# PIKE SOLAR SITE DEVELOPMENT PLAN

PCD-ENGINEERING REVIEW COMMENTS  
IN BLUE BOXES WITH BLUE TEXT

COVER PAGE

1 AREA 3 - PLAN VIEW
G103 SCALE: 1"=350'

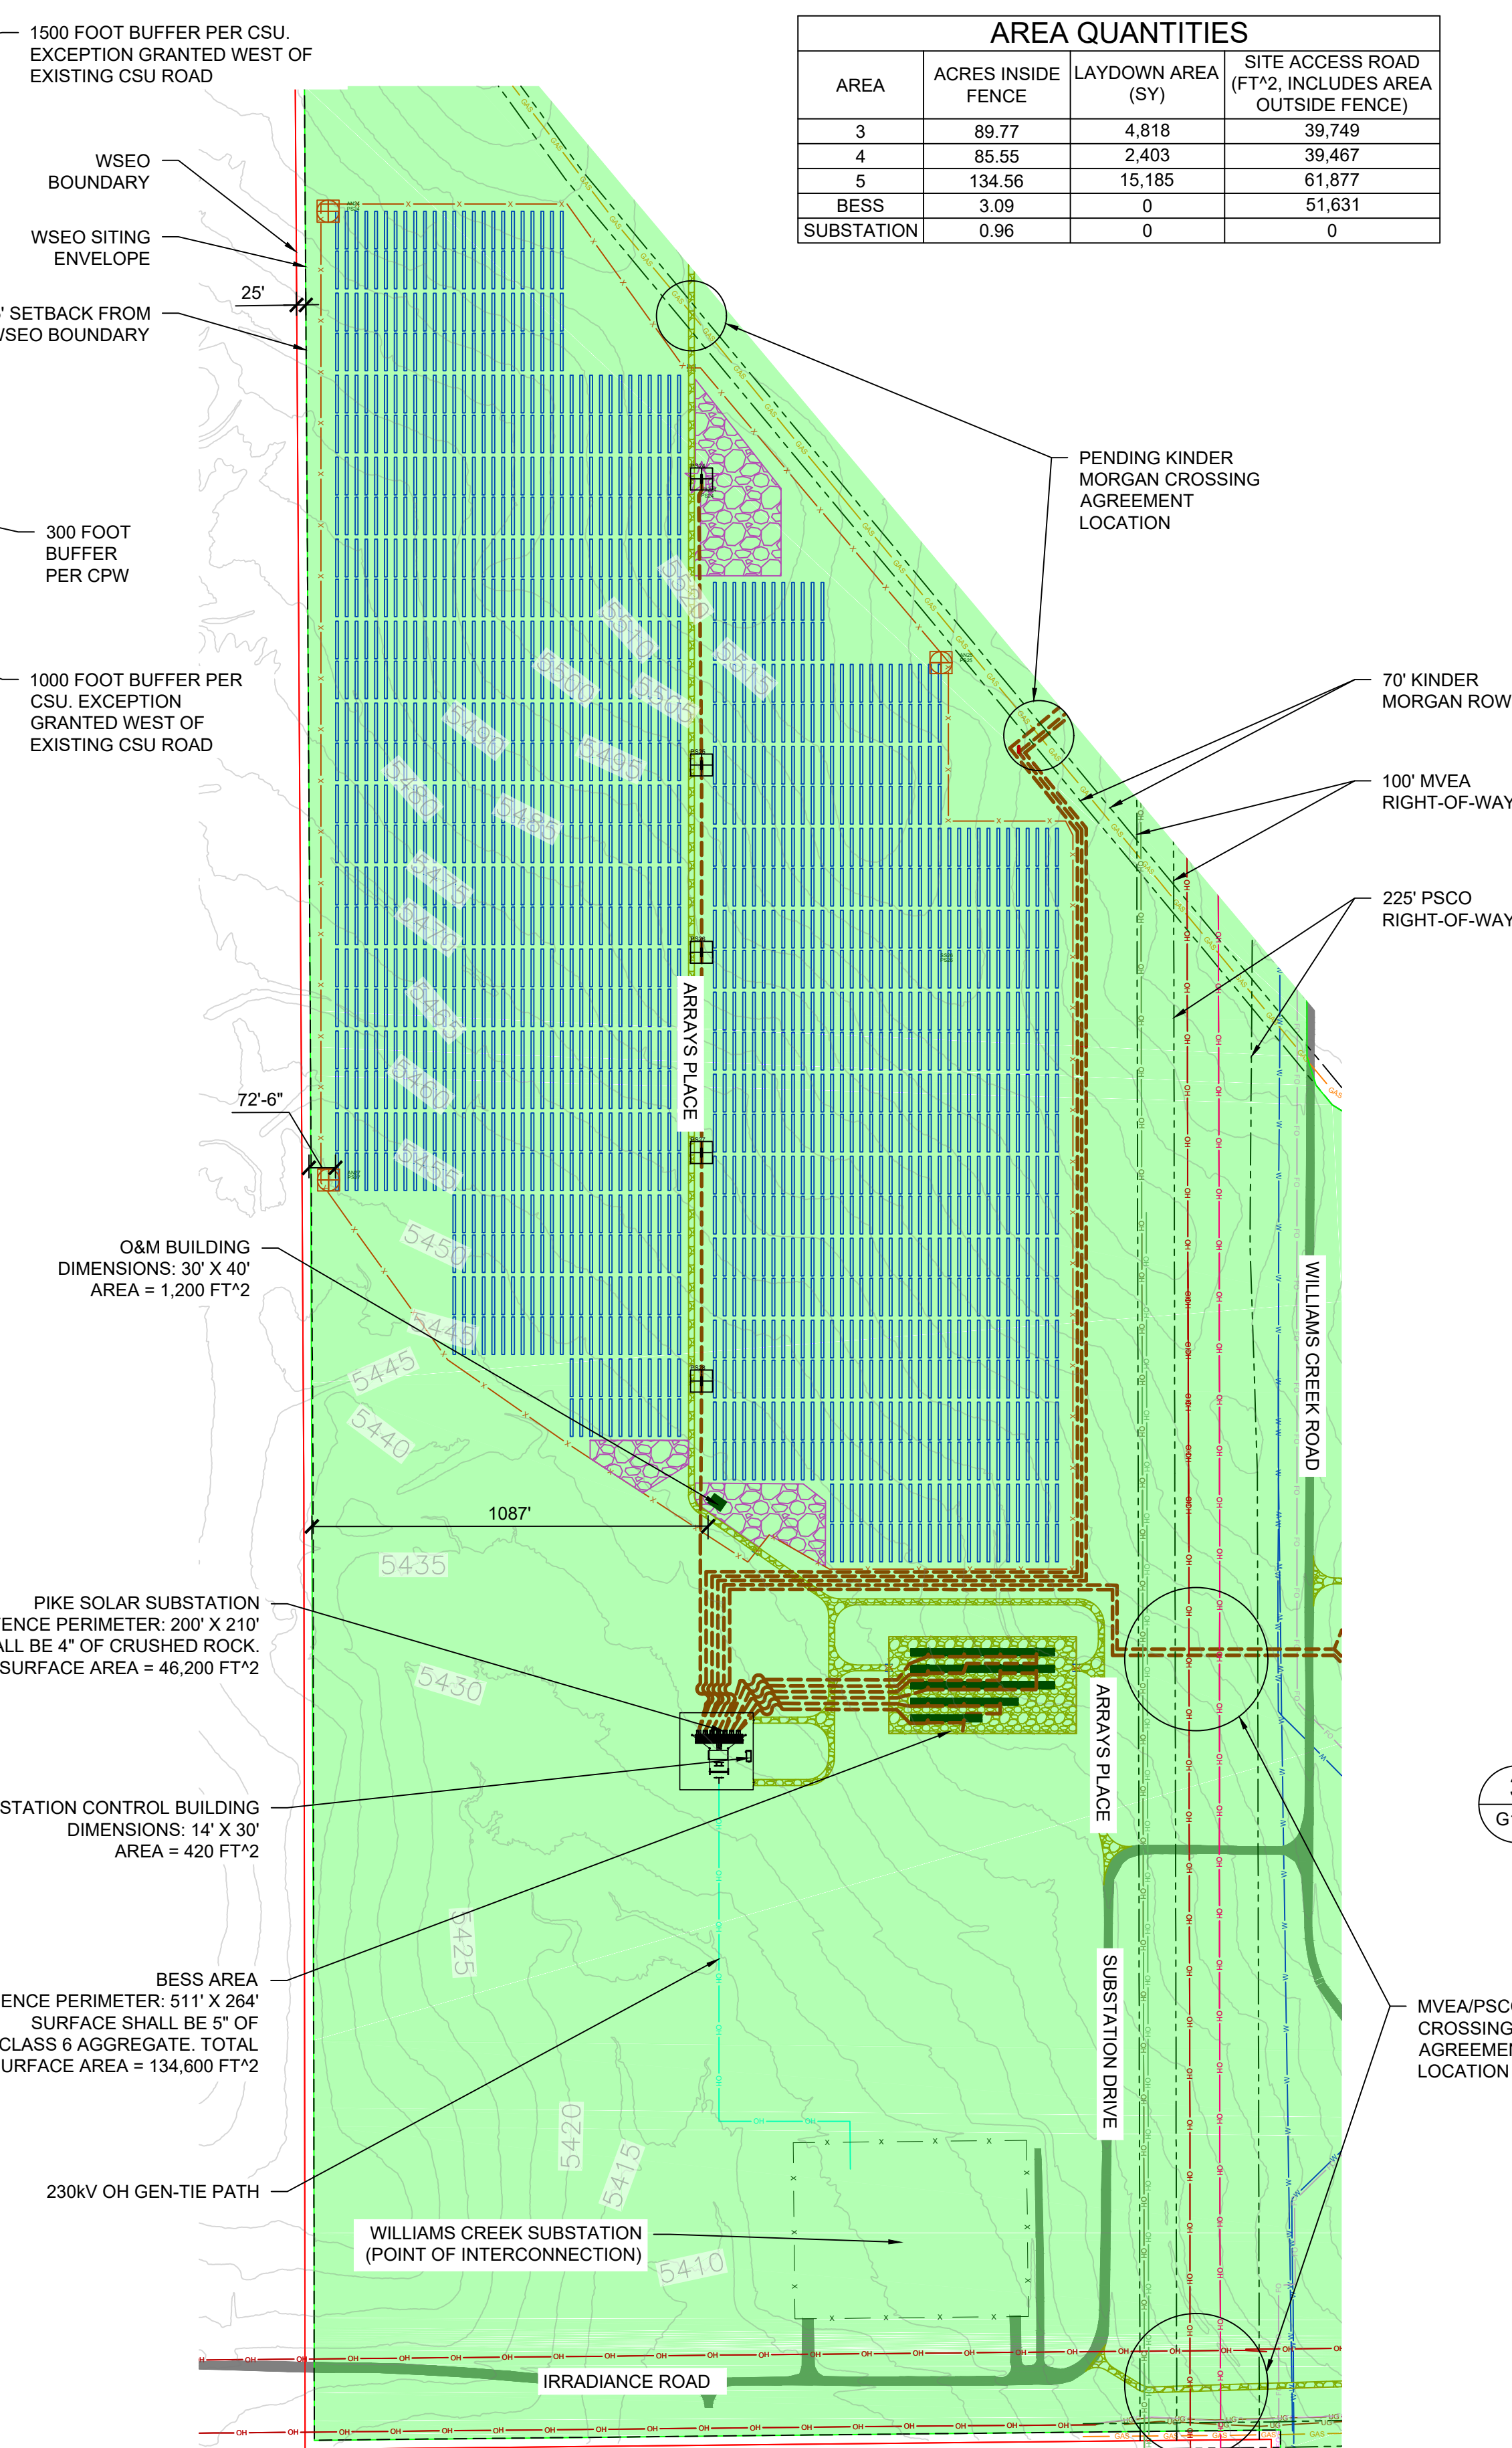
Provide details and show on all plans if there will be a building.

please provide a detail of the POLES or the Overhead lines both the 230 and 115; add a sybol for the powl locations along the lines...All Gen site plan sheets

O and M building, BESS storage bldg s add to legend all sheets, add buildings ; add building details SF and dimensions to general site plan sheets and provide a detail of the BESS, and O and M bldg distances of each wall or side, SF, height

Detail added.

G105

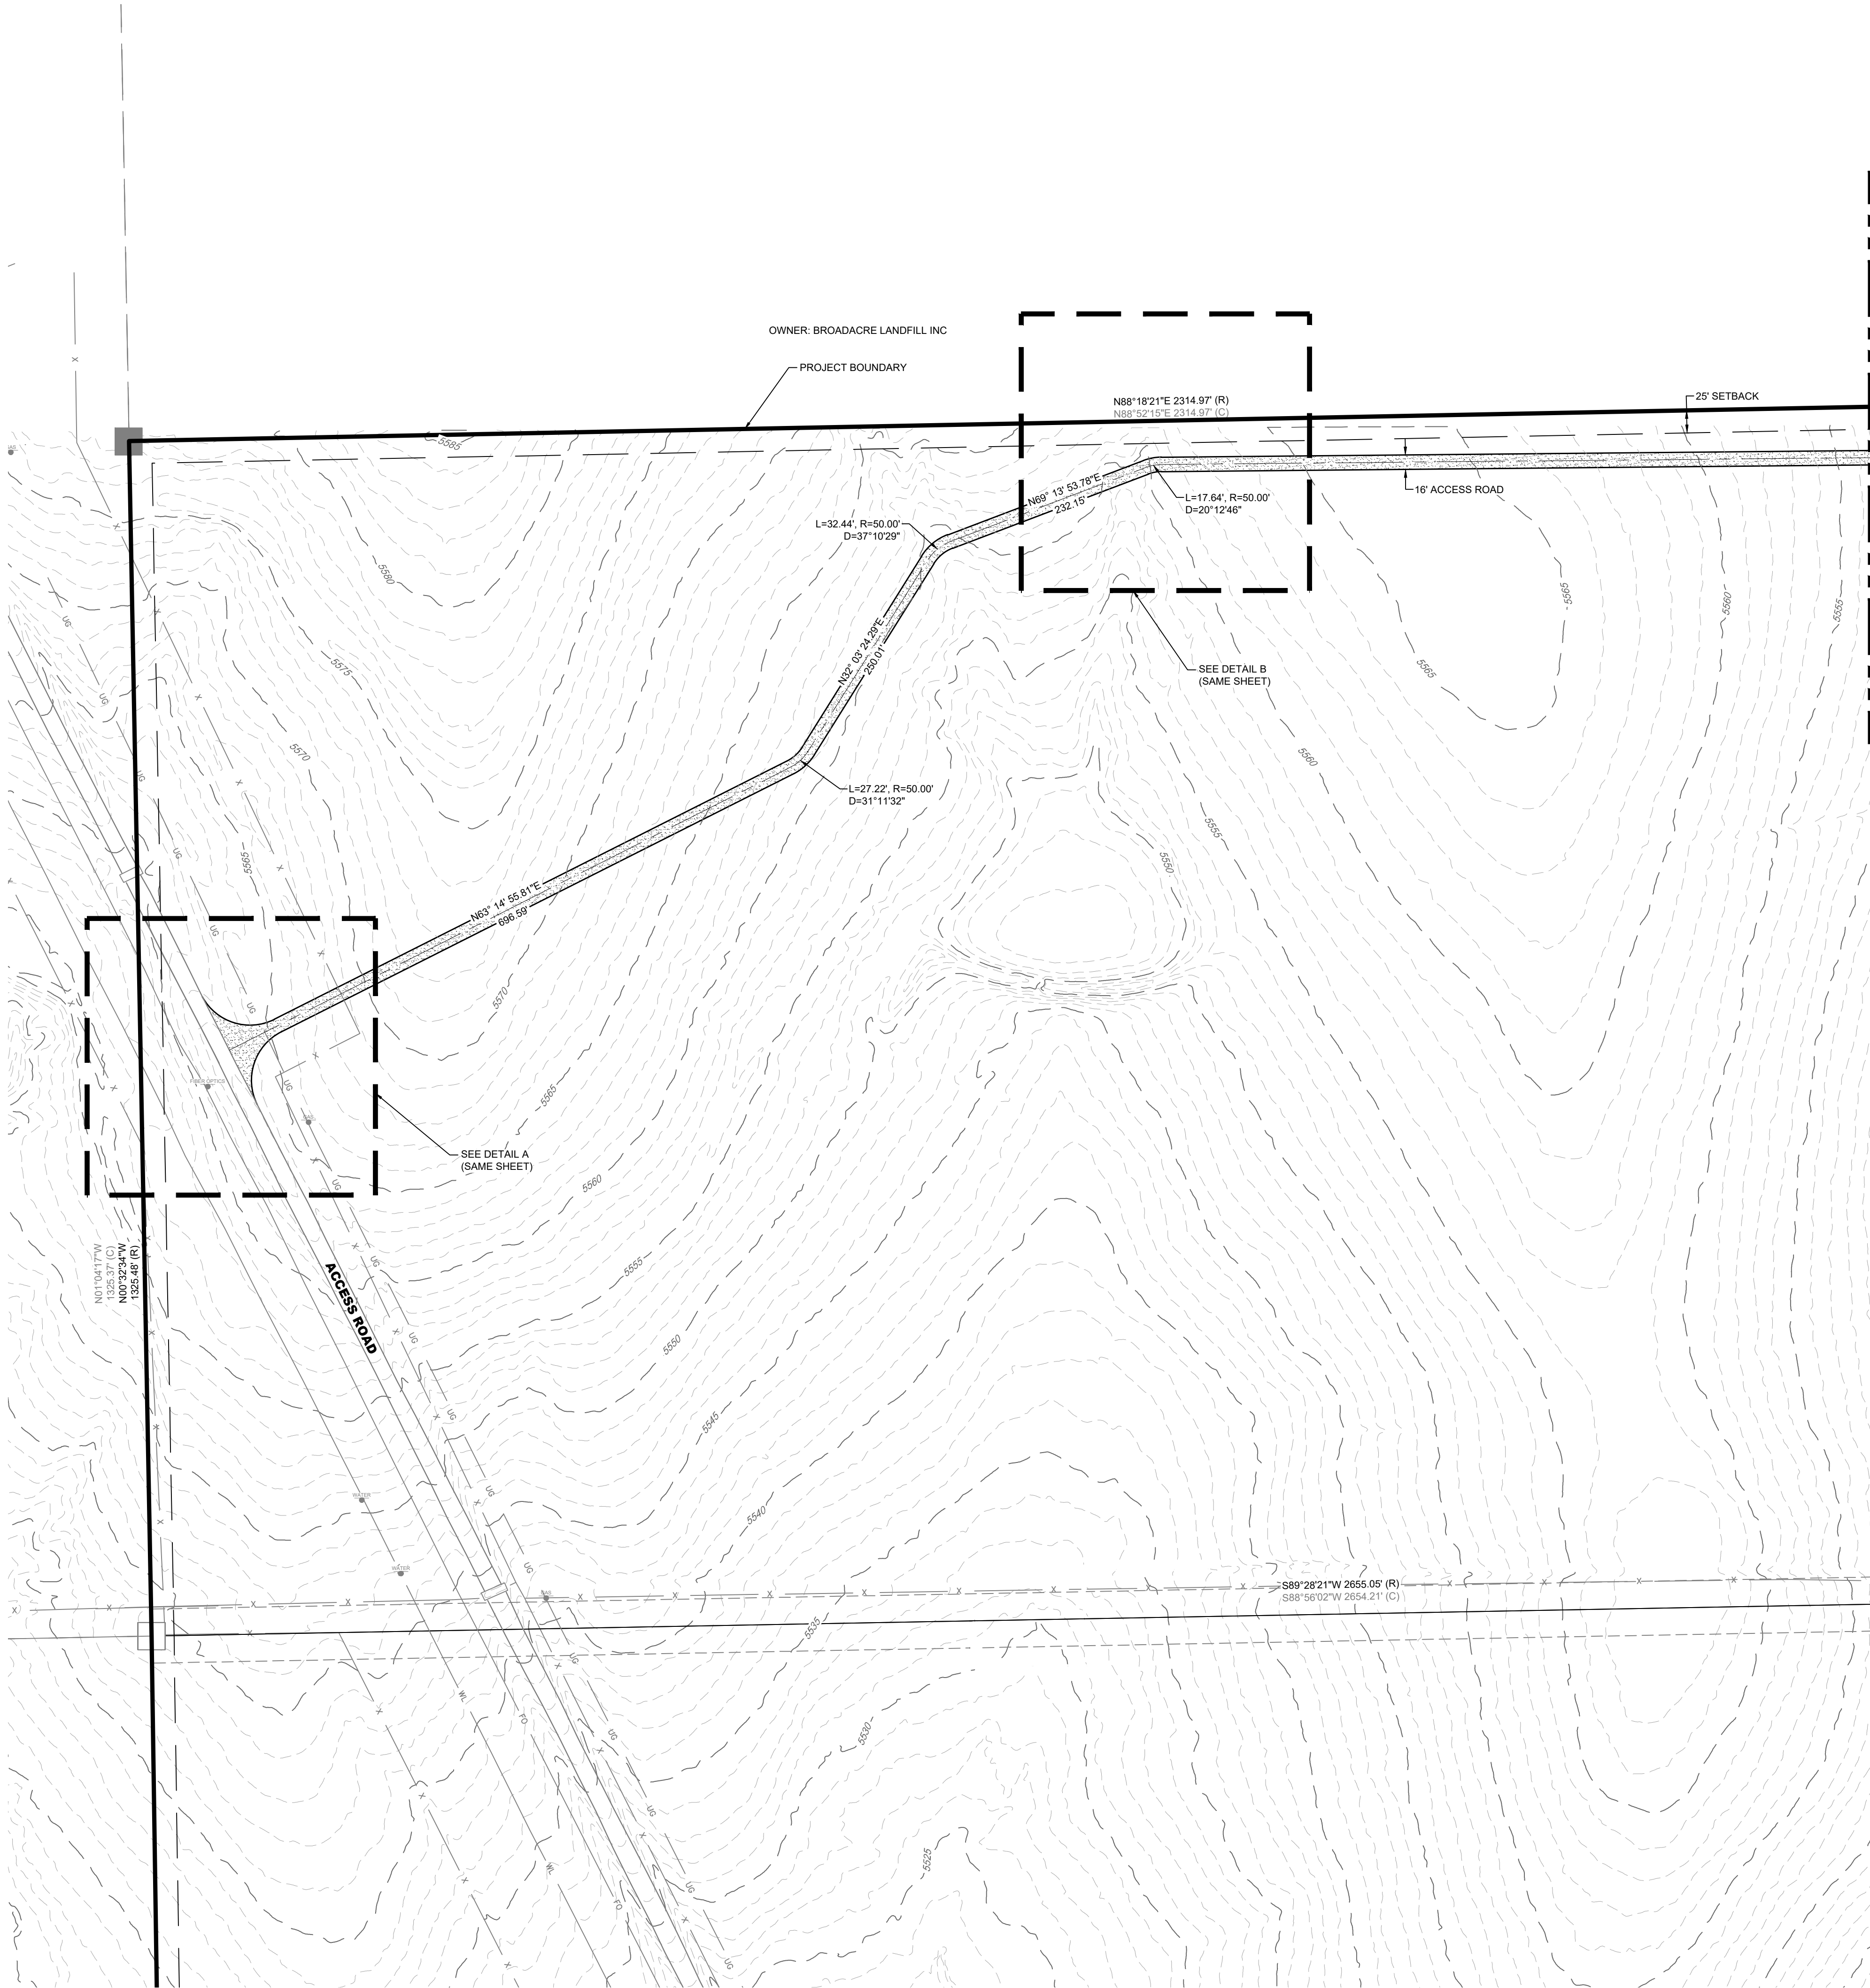
ADD his note- You may want to mak the parkig space ADA to meet requirmentns

SF total  
9x18 gravel parking space  
Add a parking space to this....
